**CITY OF ALBUQUERQUE
PLANNING DEPARTMENT
Development Review Board Comments**

**Agenda Item: 17 Project #: 1002246
Application # 02DRB-01869**

Subject: Saraton Heights Addition

DEVELOPMENT REVIEW BOARD--SPEED MEMO

**PLAT OF
LOT A, BLOCK 10
SARATON HEIGHTS ADDITION
SECTION 24, T. 10 N., R. 3 E., N.M.P.M.
CITY OF ALBUQUERQUE
BERNALILLO COUNTY, NEW MEXICO
AUGUST 2002
SHEET 2 OF 2**

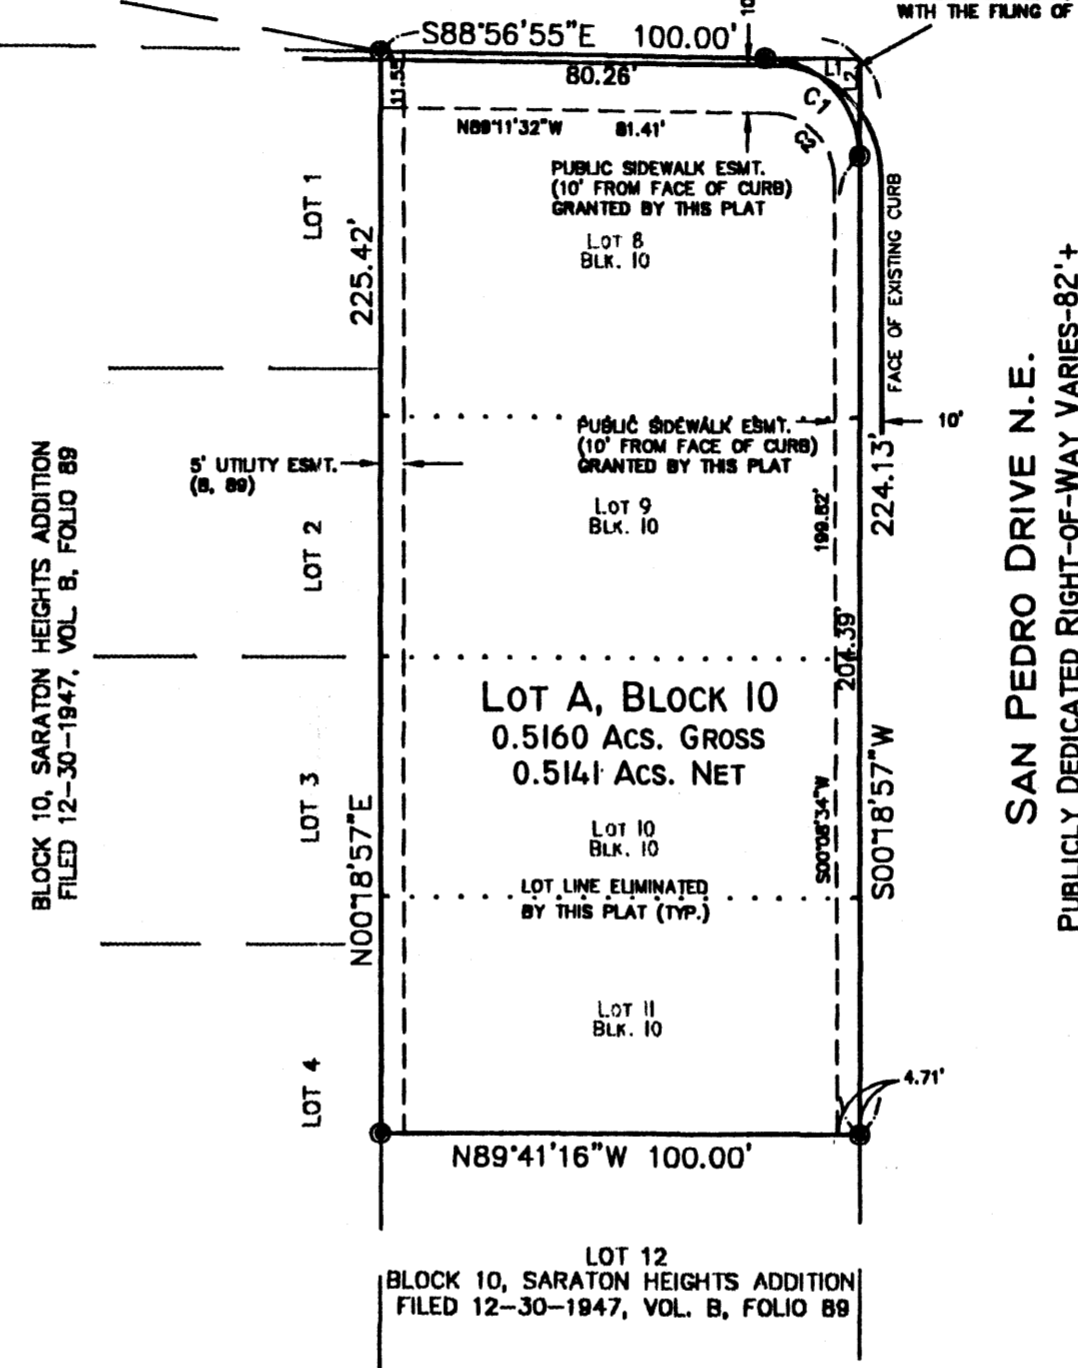
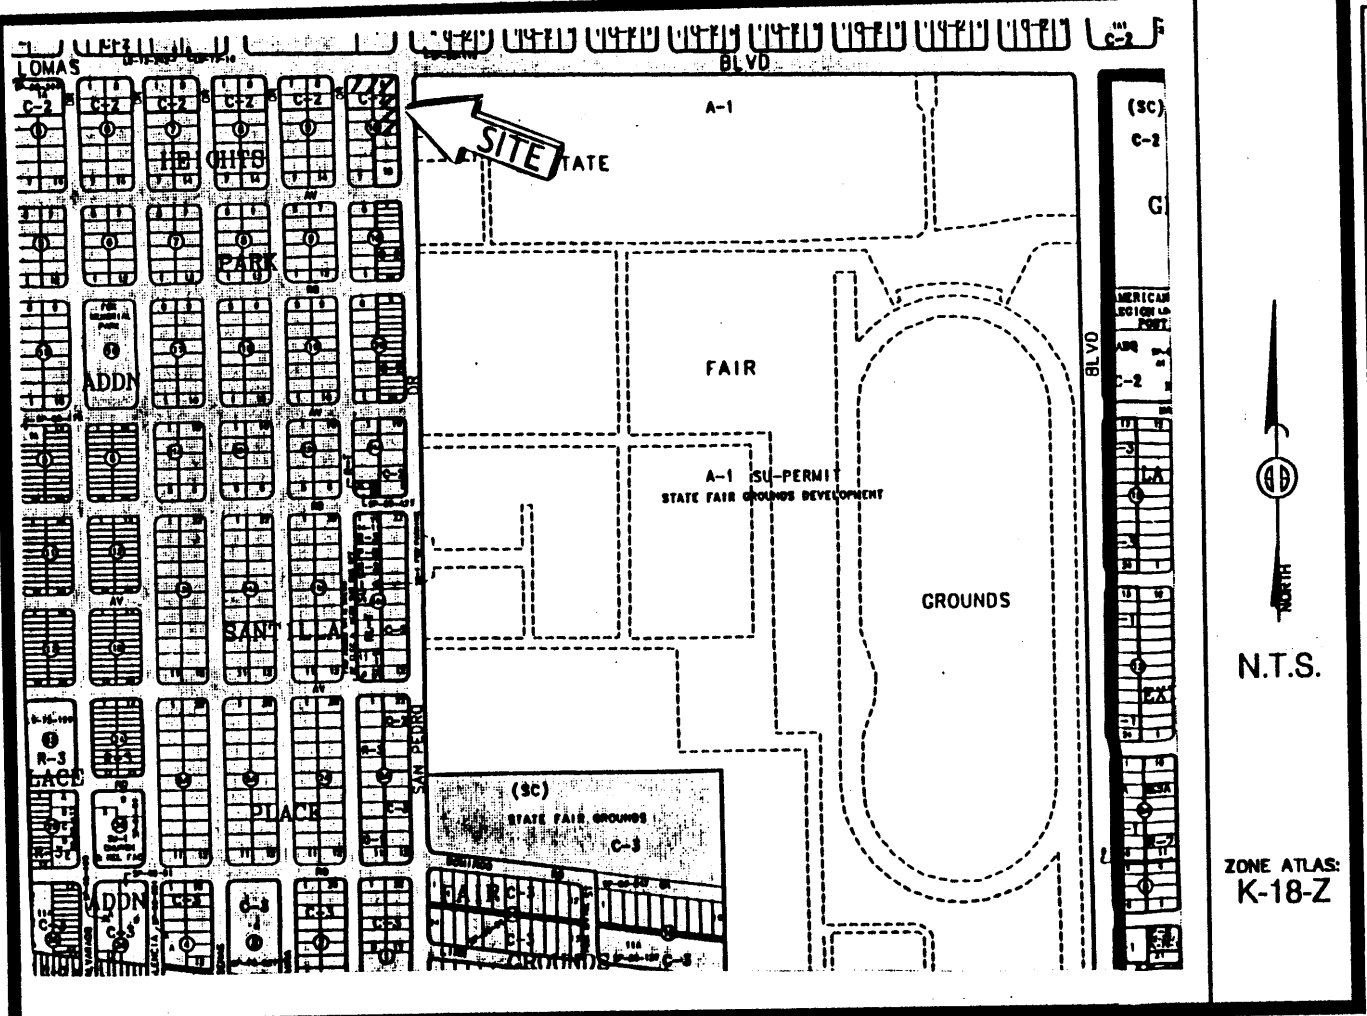
Offsite drainage easements required.

CITY	STATE	STATUS	DATE	BY
ALBUQUERQUE	NEW MEXICO		8/07/02	CAI
COUNTY:	SURVEY	ABSTRACT #	RECORDED:	PLAN CHECKED
BERNALILLO				AS-BUILT
REGIONAL DWG. NO.	CORPORATE DWG. NO.	SP-1		
30/0002	SKETCH PLAT

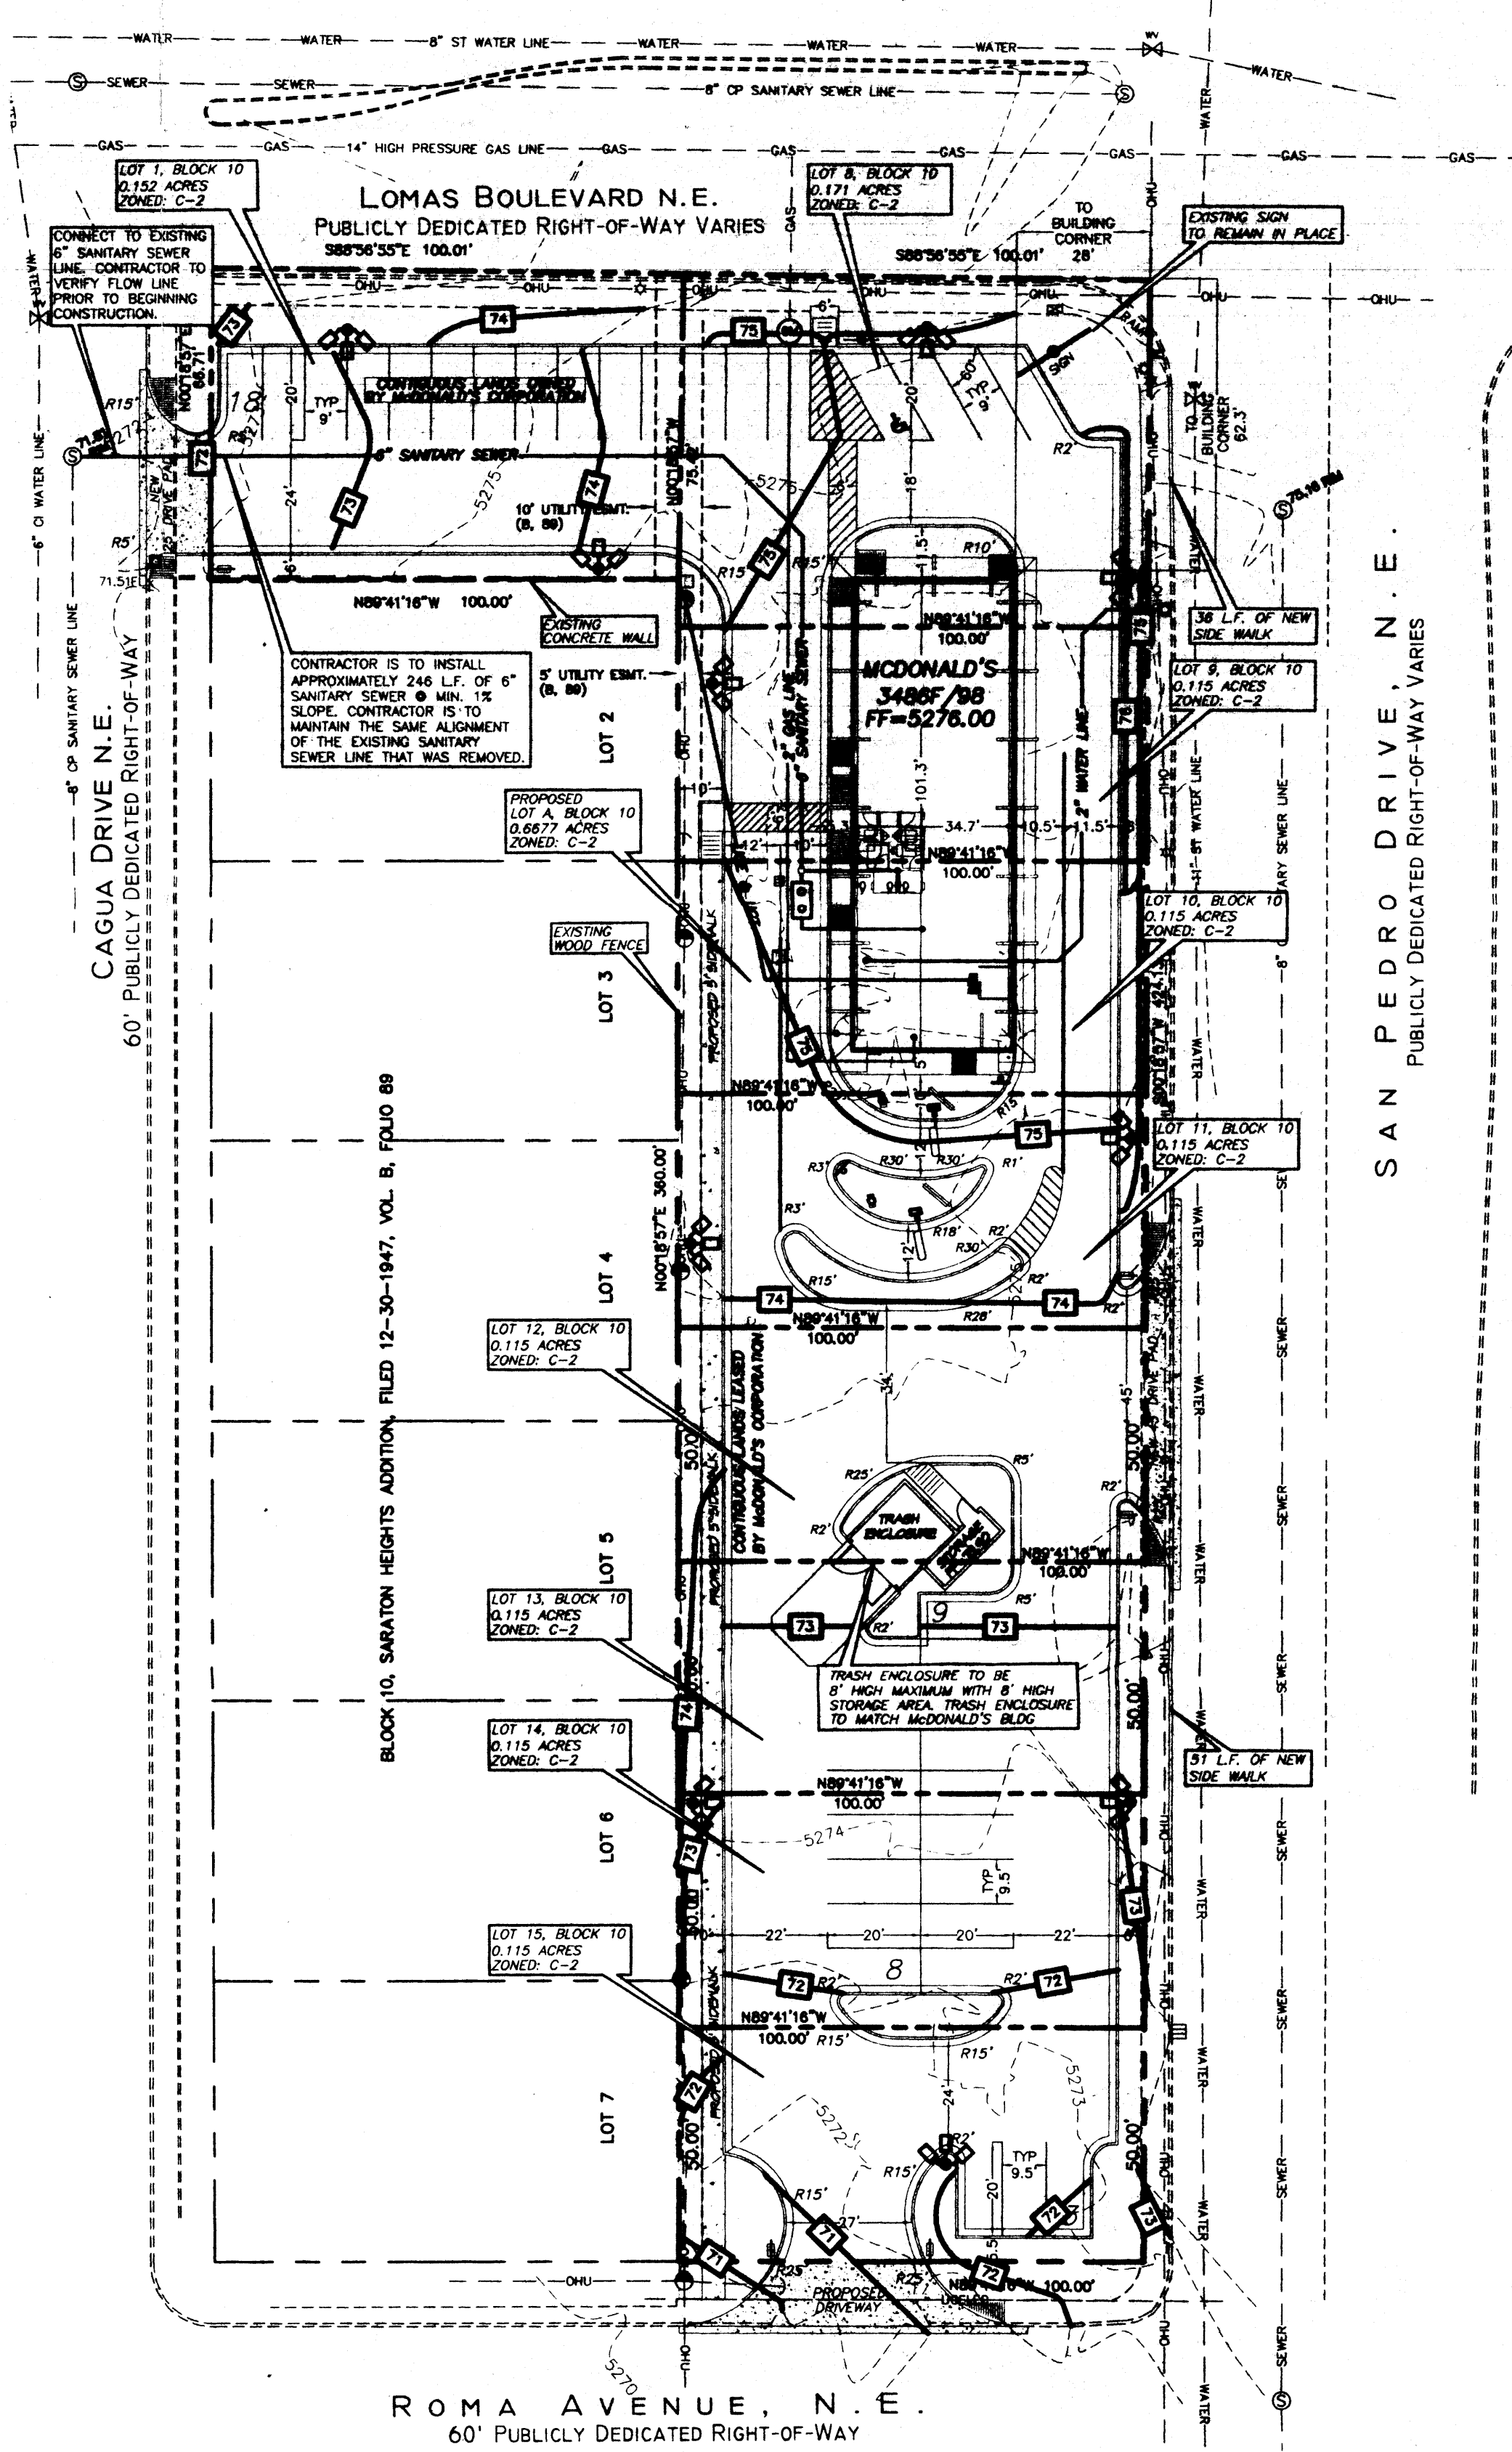
Why doesn't the plat cover all lots on this property? Will need a private drainage easement across remaining lots at building permit.

No.	Comment
□	10 ft of right-of-way dedication is needed from the face of the curb for Lomas and San Pedro.
